**KIRKLEES METROPOLITAN COUNCIL
INVESTMENT & REGENERATION SERVICE**

DELEGATED DECISION TO DETERMINE PLANNING APPLICATIONS

Reference No: 2021/62/92658/E

Site Address: The Abbey, 171, Abbey Road, Shepley, Huddersfield,
HD8 8DY

- PROPOSED EXTERNAL MATERIALS
- MASONRY
 - NATURAL COURSED STONE
 - ROOF TILES
 - STONE SLATE
 - WINDOWS/DOORS
 - PAINTED TIMBER (COLOUR TBC)
 - RAINWATER GOODS
 - COLOUR MATCH ALUMINIUM

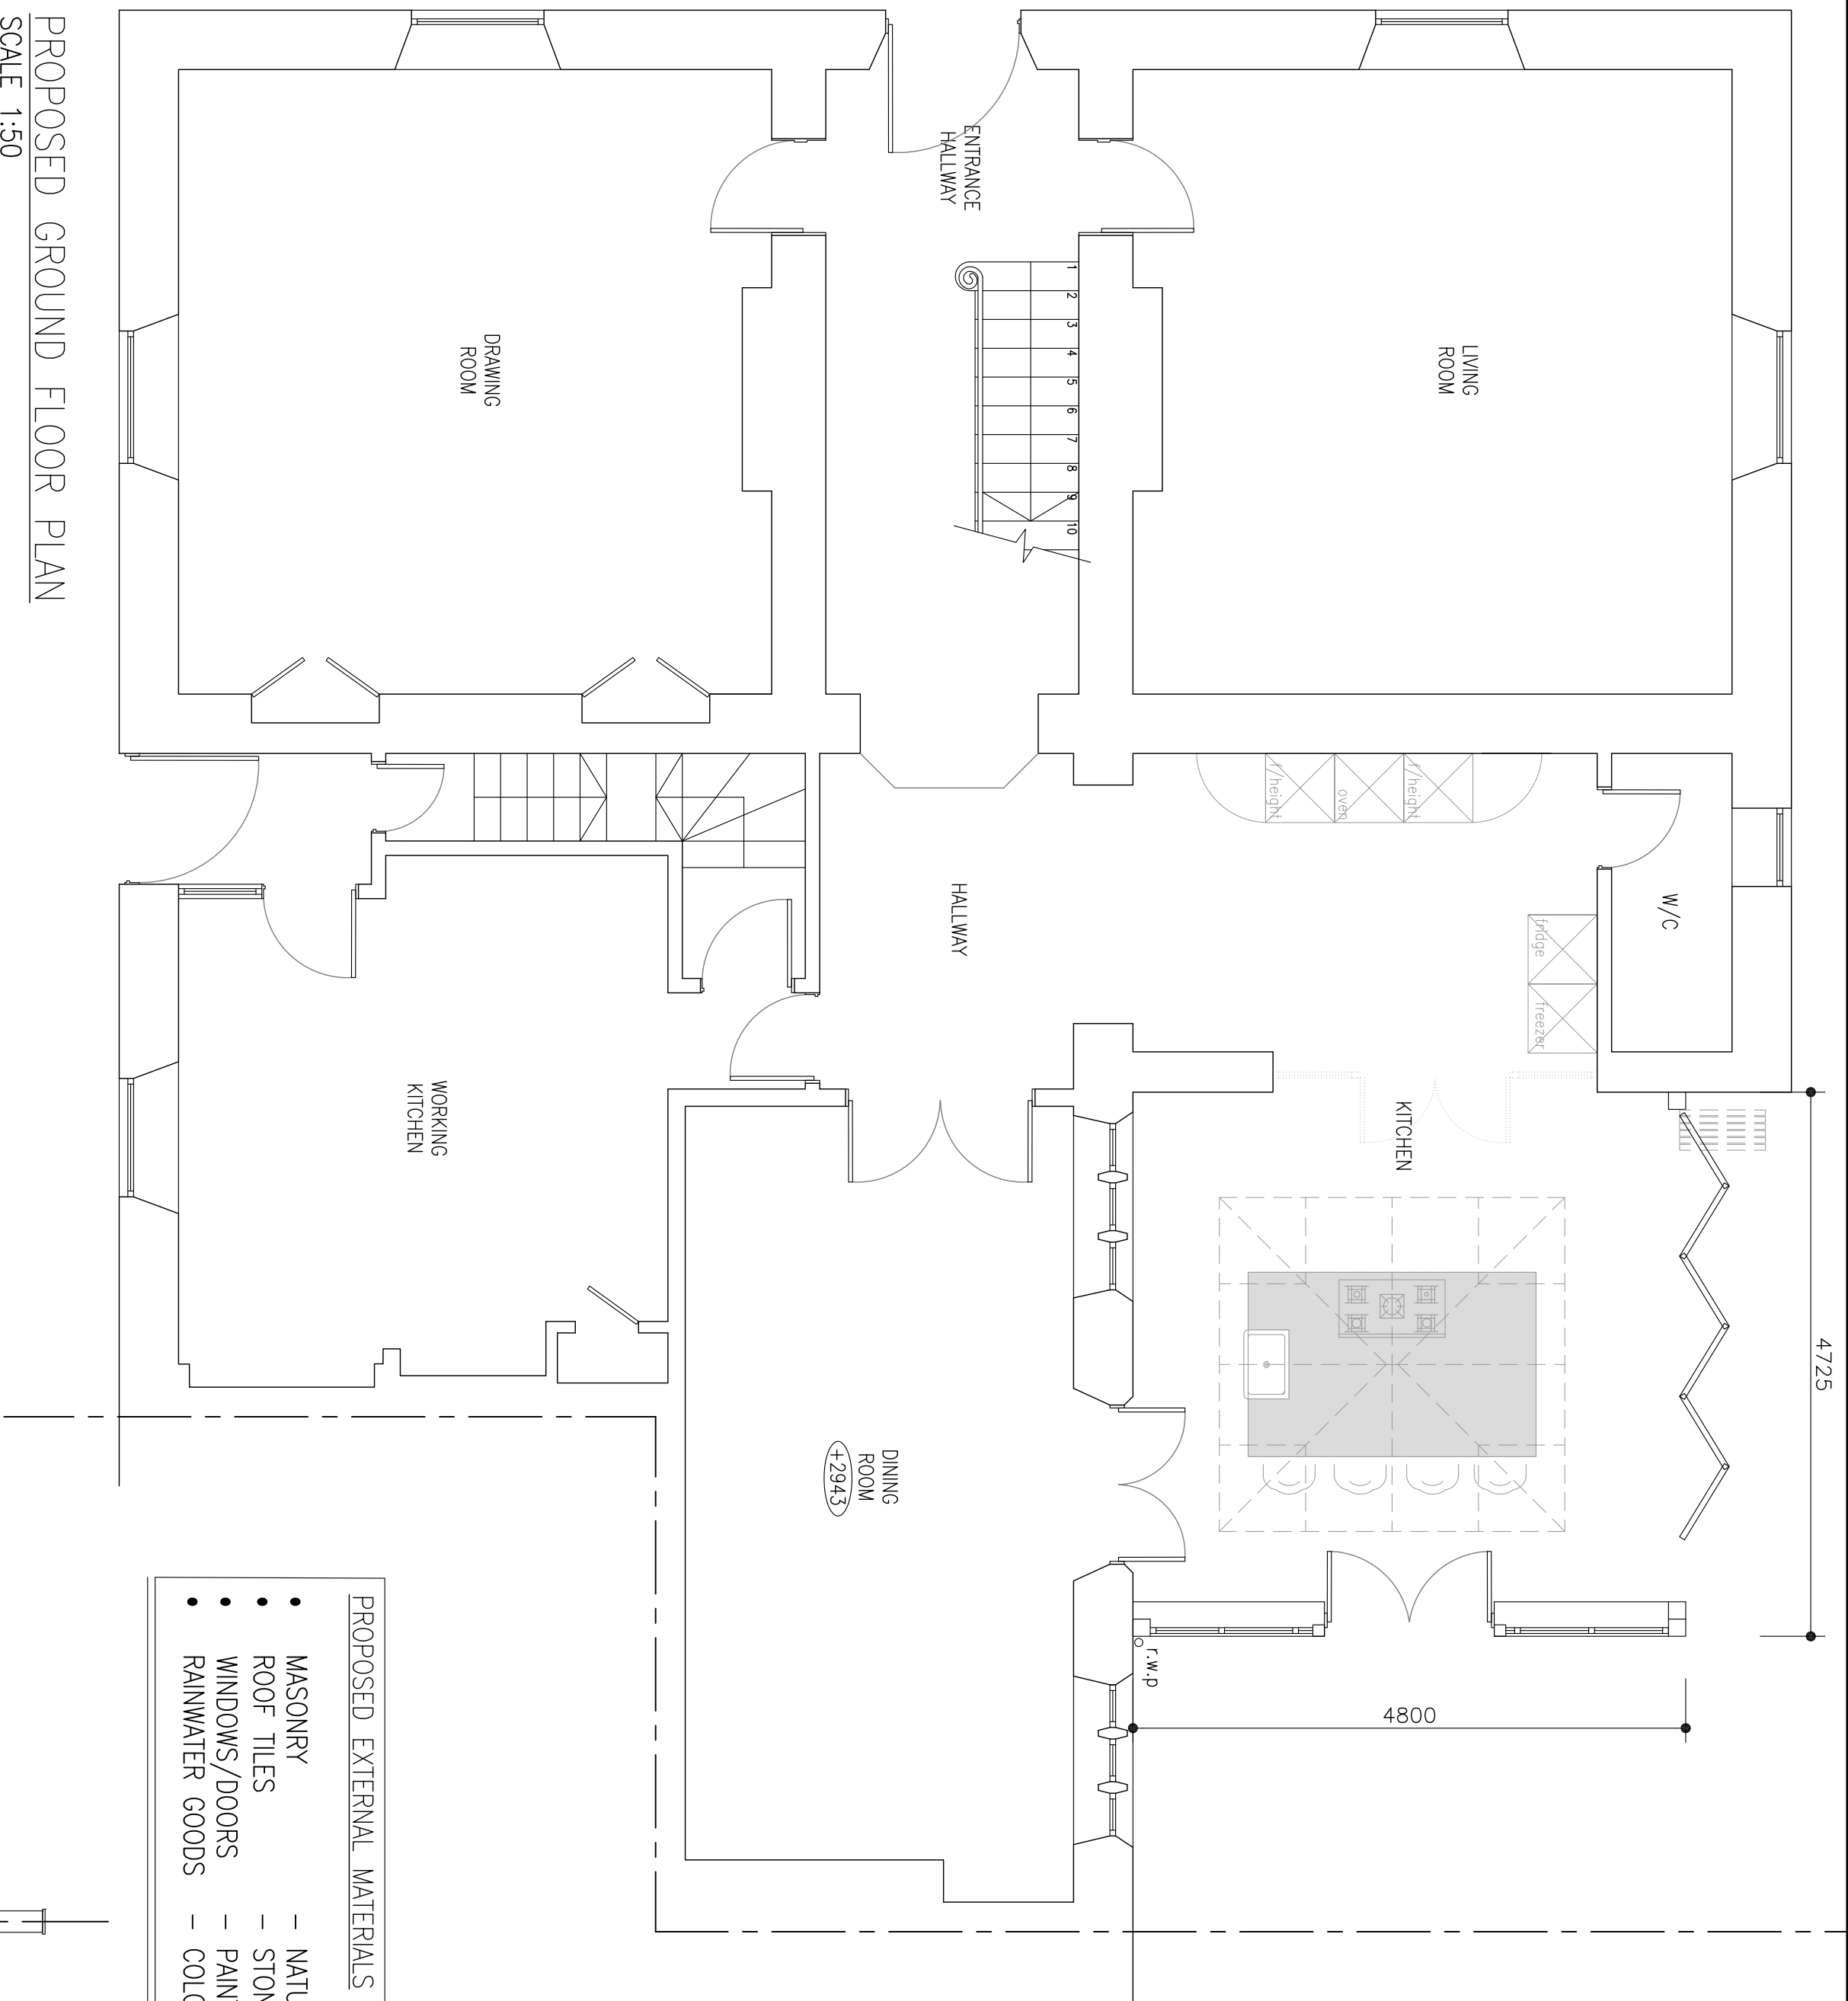
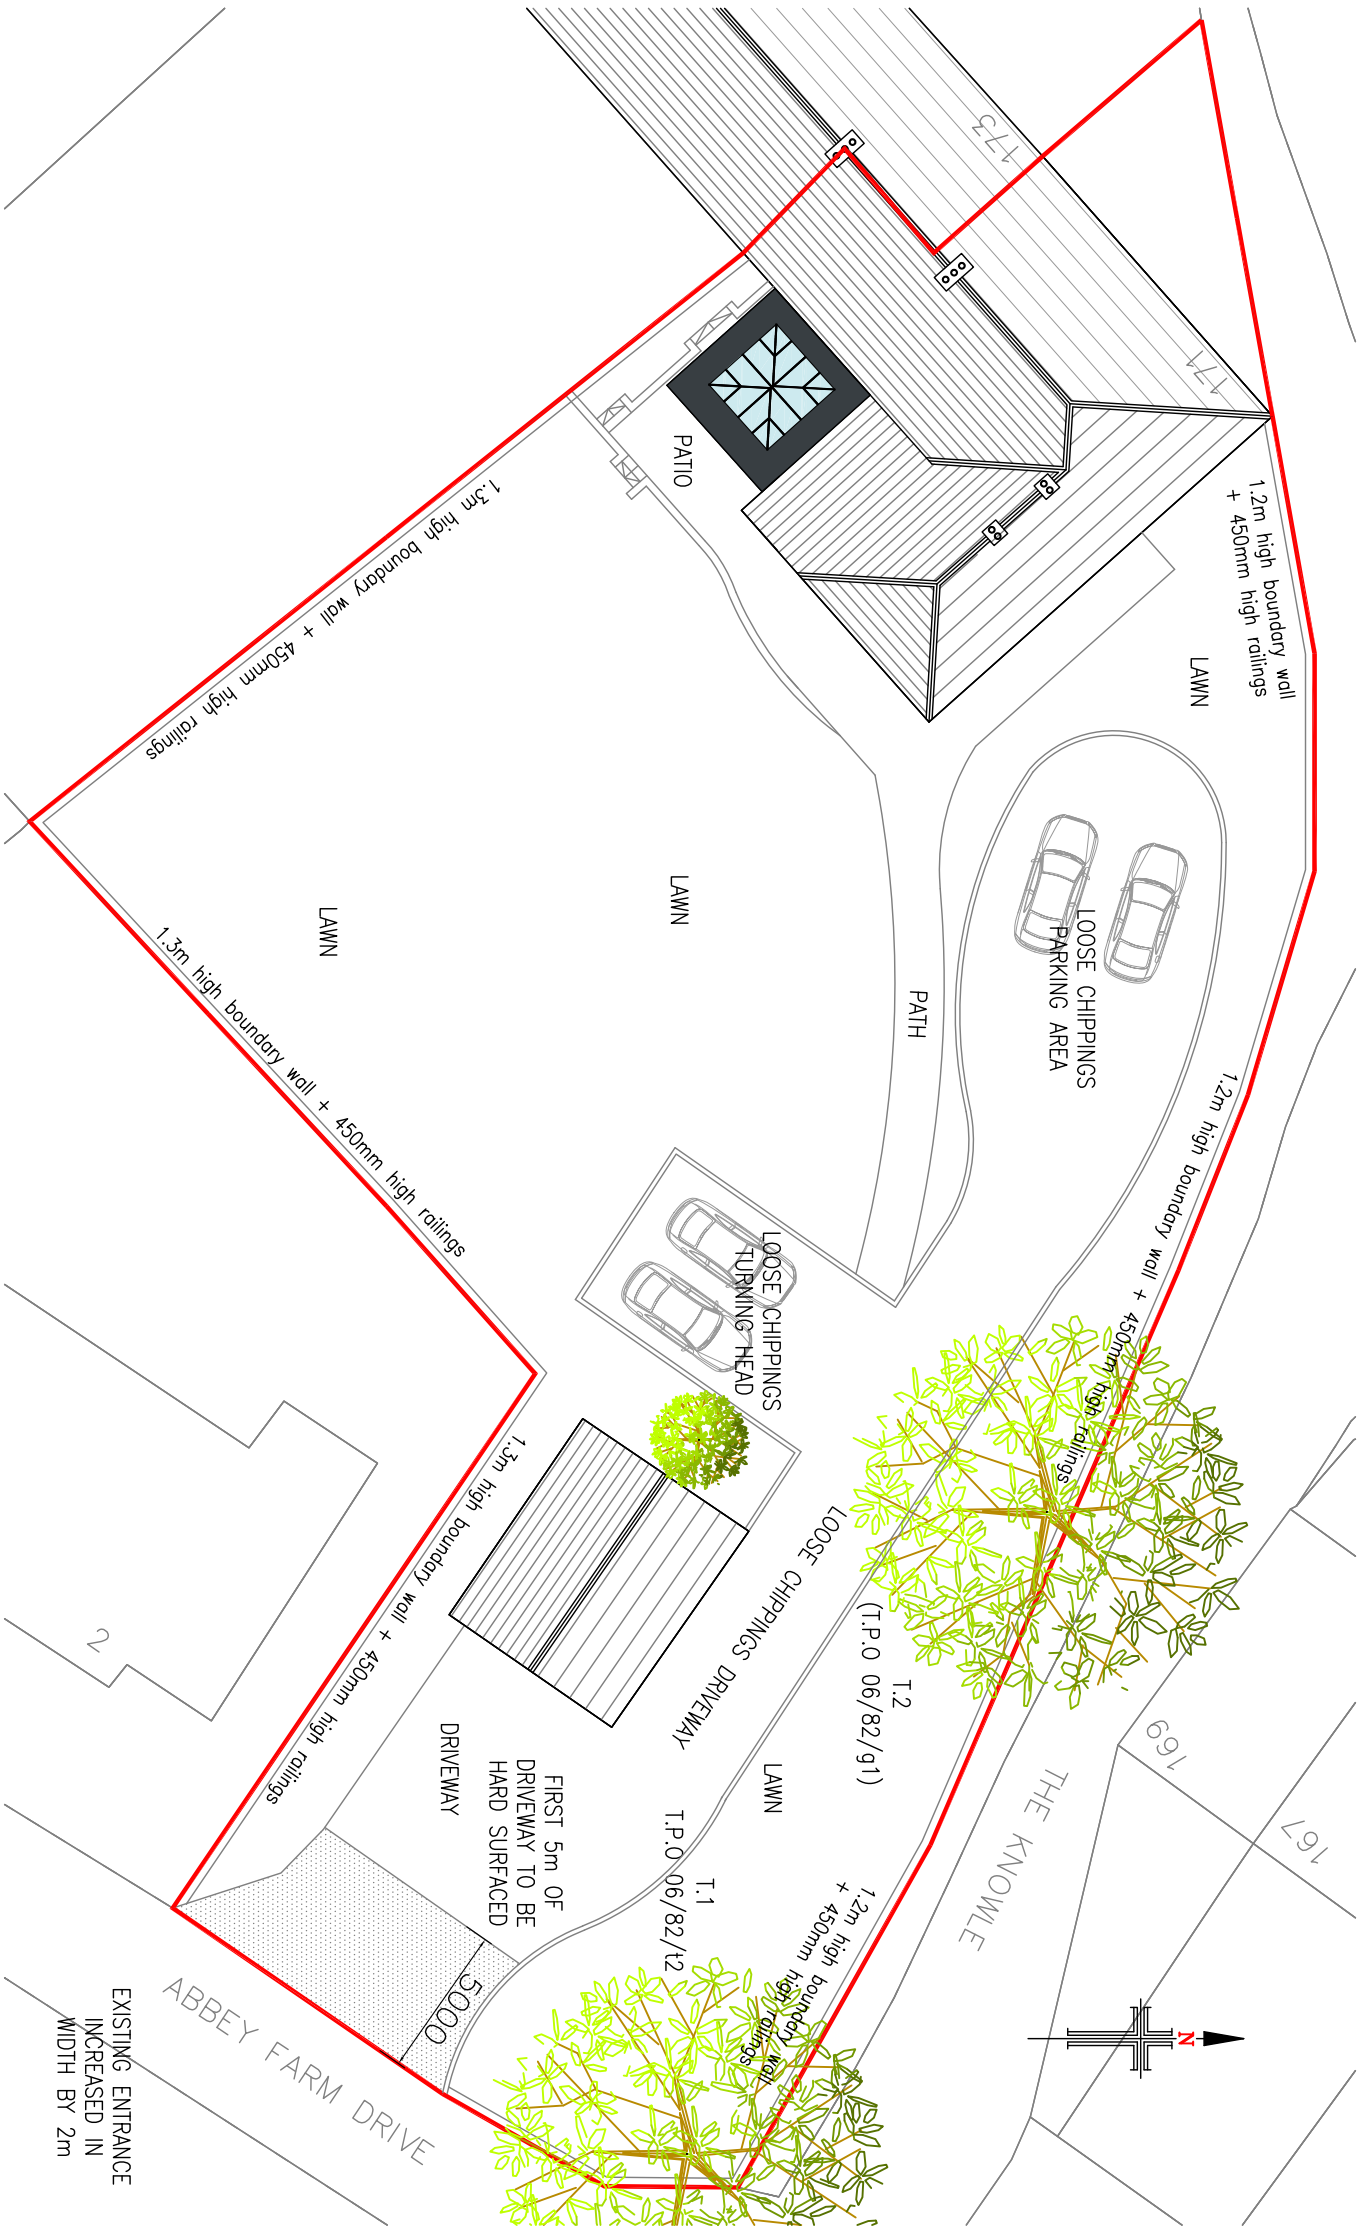
The KC Highways Development Management team asked that the first five metres of the access driveway be hard surfaced, so that loose chippings are not transferred onto the highway. The agent submitted amended plans demonstrating this, which are considered acceptable.

The KC Highways Development Management team requested that the first five metres of the access driveway be hard surfaced so that loose chippings would not be transferred onto the highway. The agent submitted amended plans demonstrating this, which are considered acceptable.
